Our Ref: EN010053

Date: 4 August 2015

**Application by Smart Wind Ltd for an Order Granting Development Consent  
for Hornsea Offshore Wind Farm (Zone 4) - Project Two**

**Request for further information**

## Plan of the indicative cable corridors at the National Grid substation for the Project, Hornsea Project 1 and C.GEN

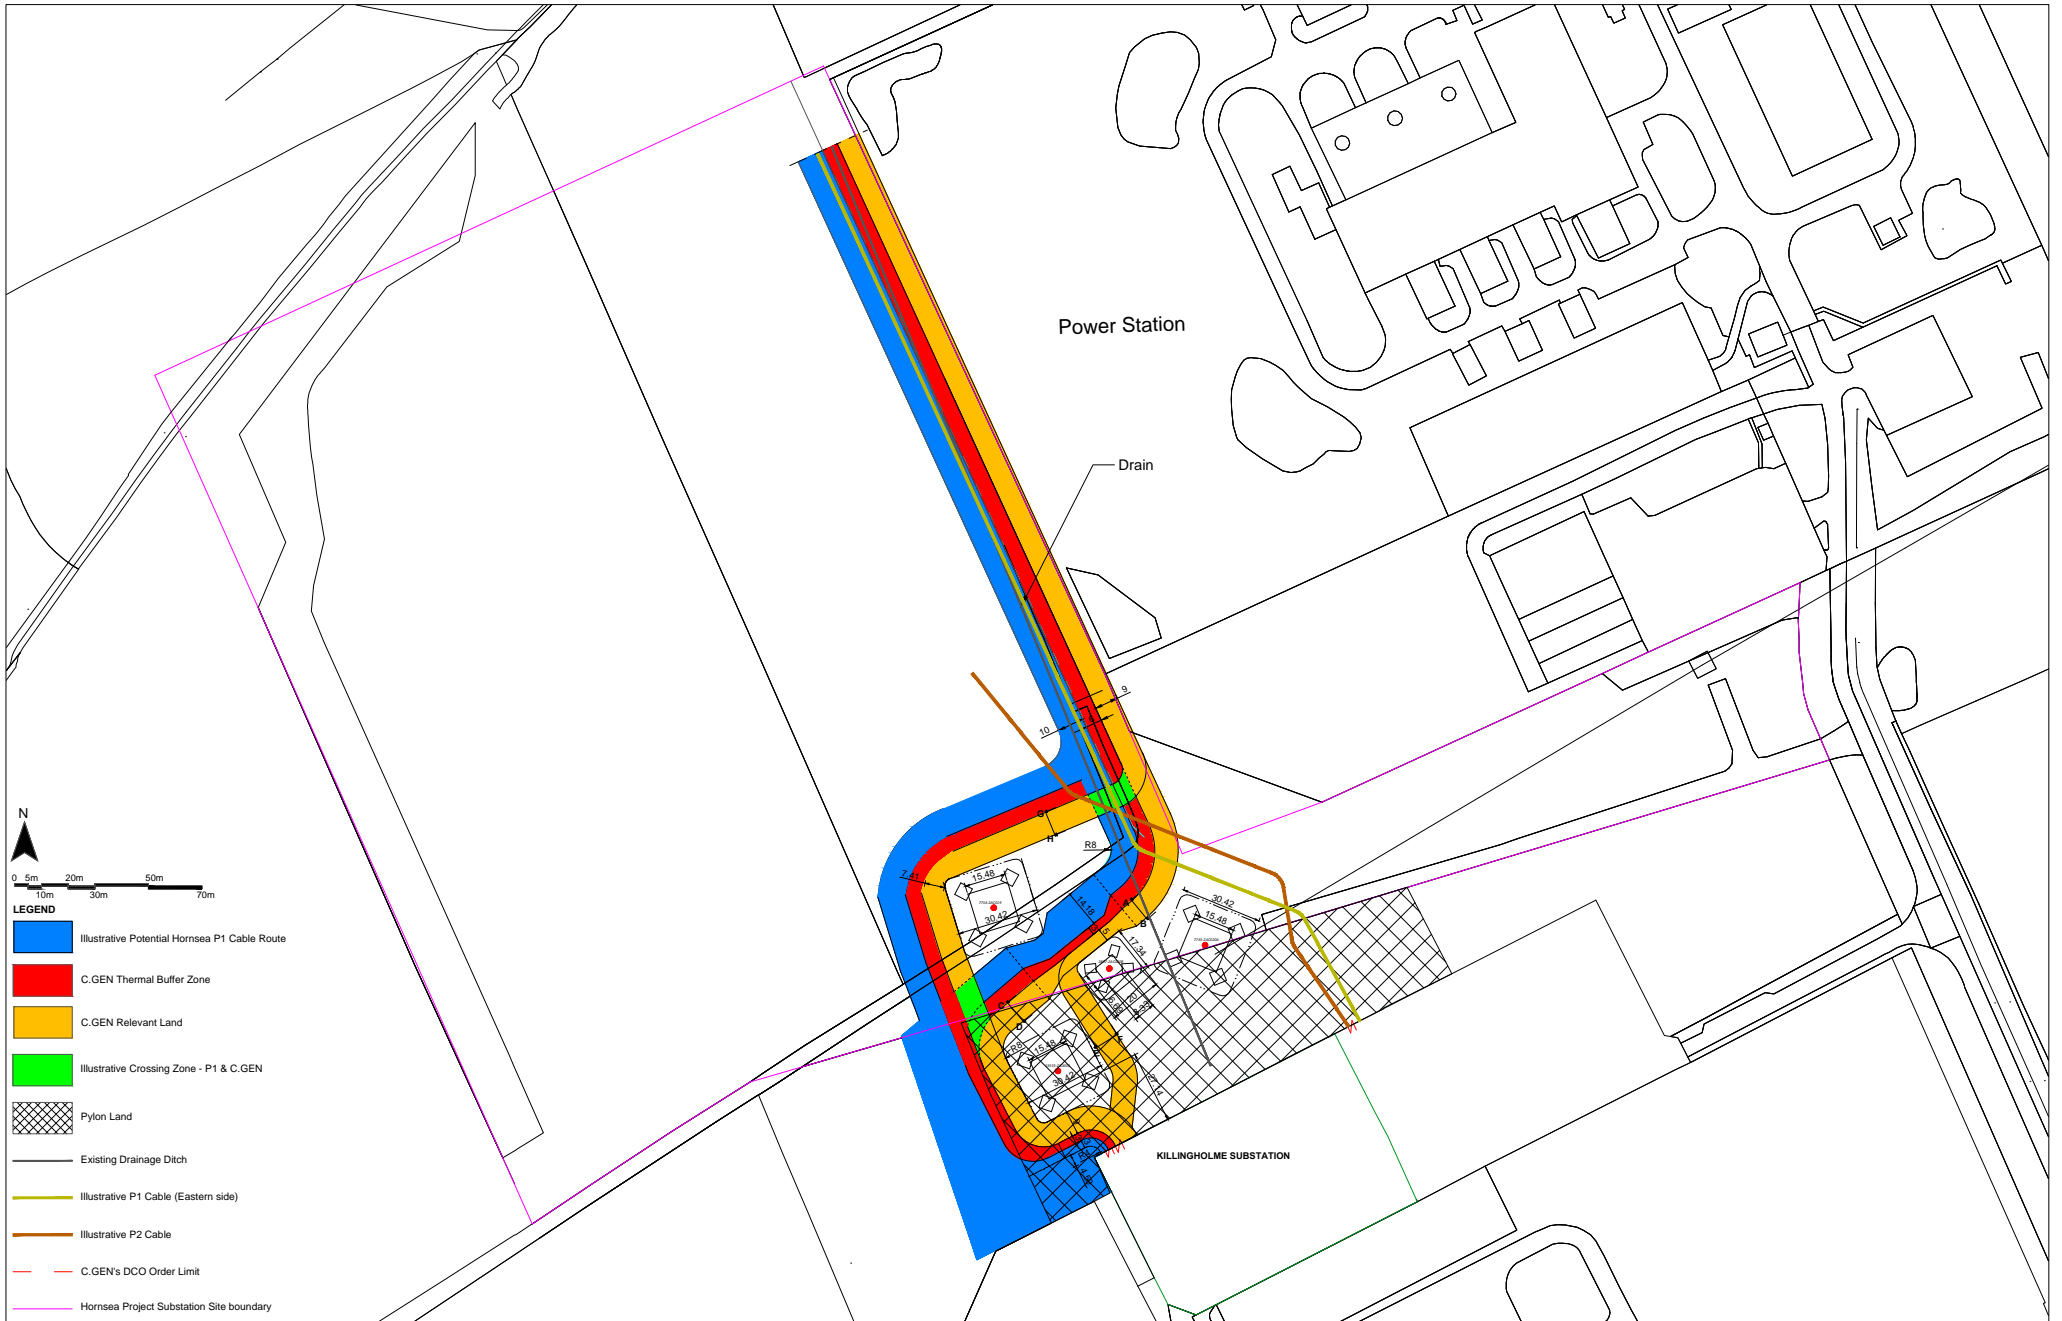
1. A map of all the cable corridors, agreed or planned, at the sub-stations/National Grid connections site, for Hornsea Project 2 (A and B), Hornsea Project 1 and C.Gen. This is to include any applications under the Electricity Act 1989, Planning Act 2008 and Town and Country Planning 1990.
2. Again, in relation to the sub-stations/National Grid connections site, and its immediate environs, a plan (with text as appropriate) explaining all extant permissions, and applications, plus the planning permission notice and accompanying approved site layout and elevation plans (if available) of the adjoining proposed Able Logistics Park development.
3. Draft Protective Provisions between Hornsea Project 2 and C. Gen, and between Hornsea Project 2 and Hornsea Project 1.
